**Addendum No. 1**

RE: Contract ID: C200842  
WBS # 33093.3.1  
F. A. # BRSTP-1127 (8)  
Henderson County (B-3475)  
Culvert on Wash Creek and  
Approaches on SR-1127 (Kanuga Road).

**August 17, 2004 Letting**

STATE	STATE PROJECT REFERENCE NO.	SHEET NO.	TOTAL SHEETS
N.C.	B-3475	EC-1	
STATE PROJ. NO.	F.A. PROJ. NO.	DESCRIPTION

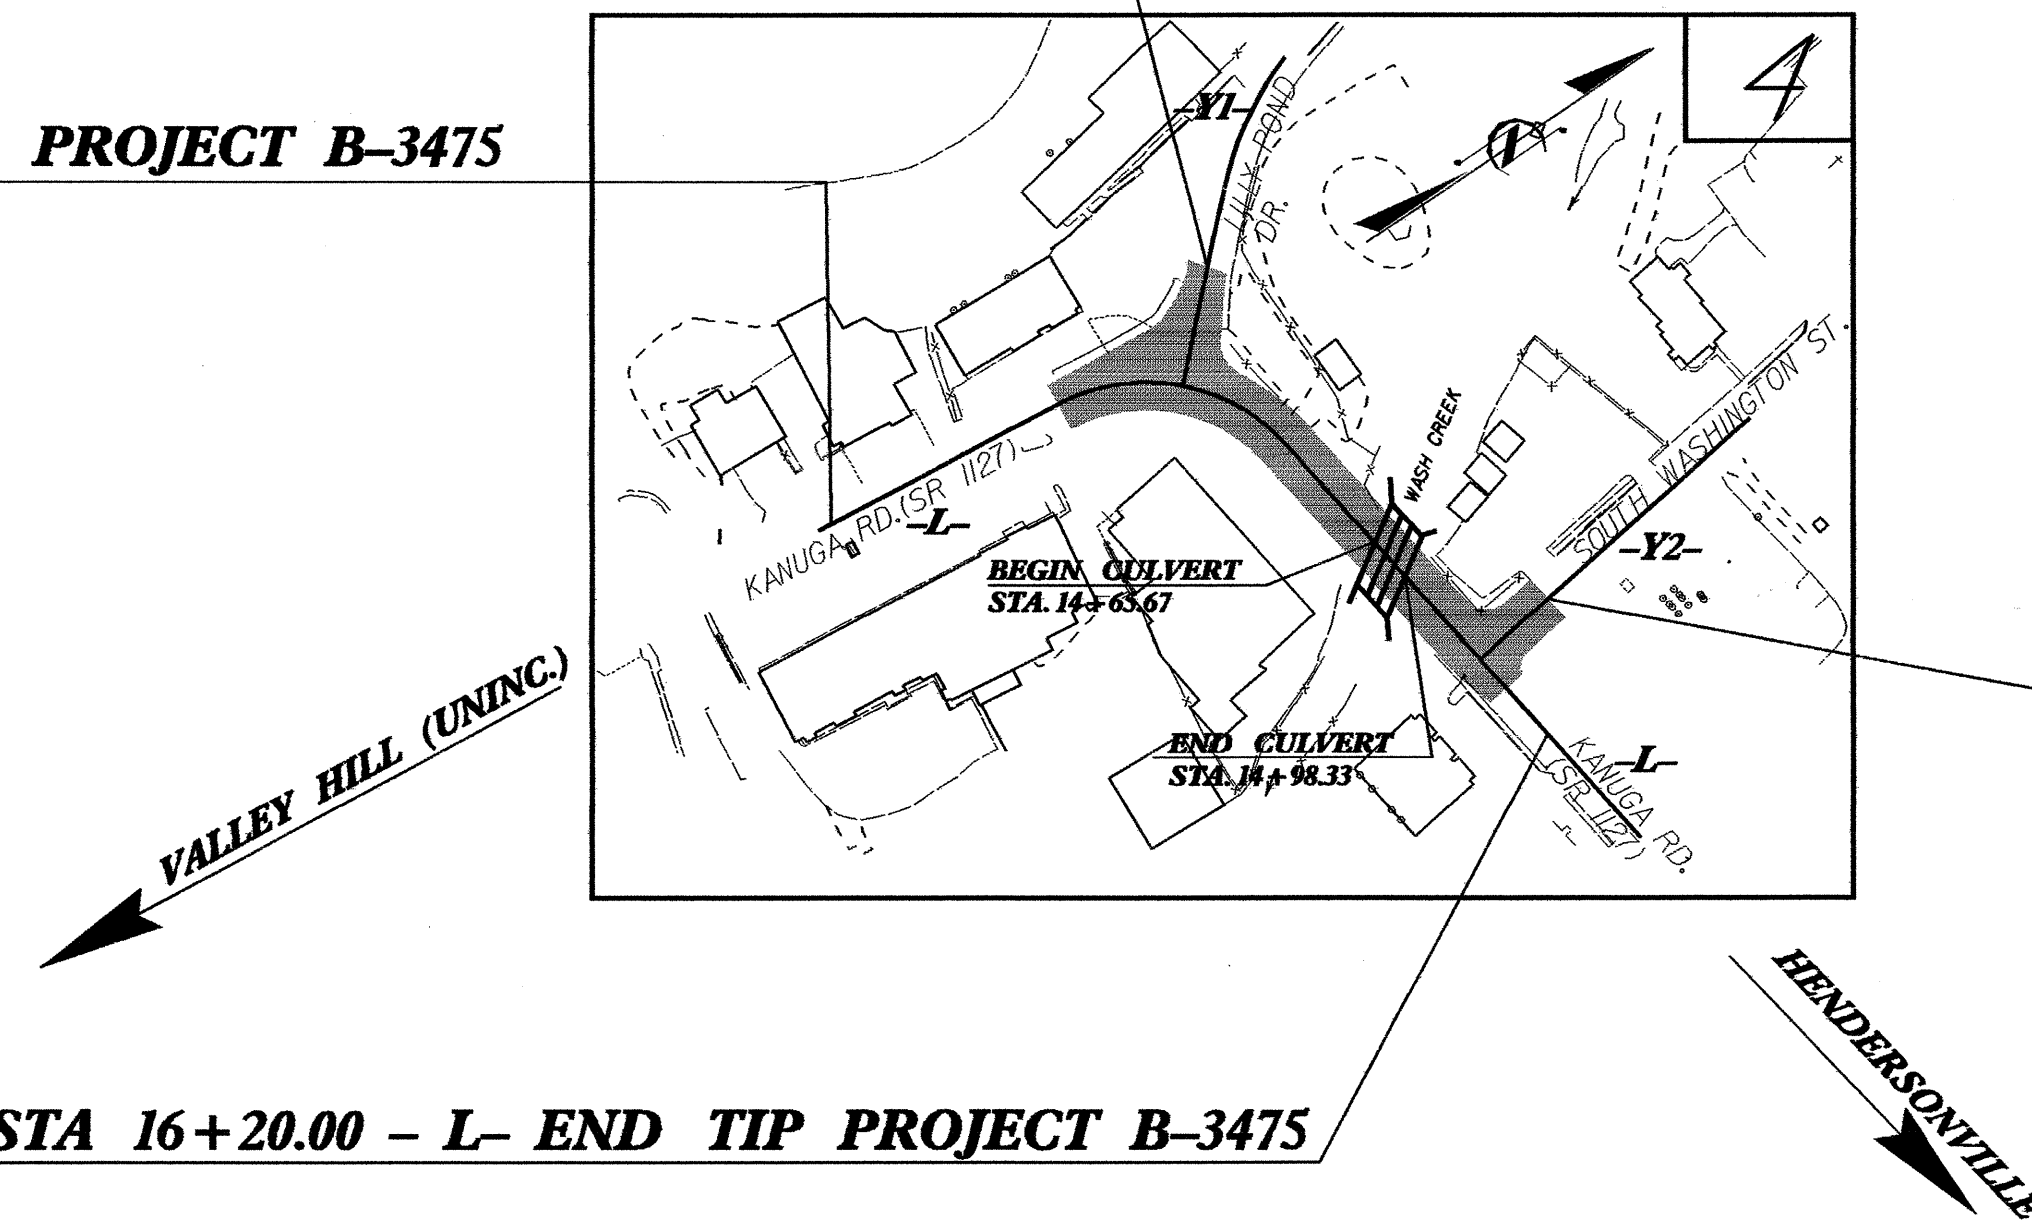
Sheet Nos. EC-1, EC-3 and EC-5 have been revised to meet the design standards for sensitive watersheds. Please void Sheet Nos. EC-1, EC-3 and EC-5 in your plans and staple the revised Sheet Nos. EC-1, EC-3 and EC-5 thereto.
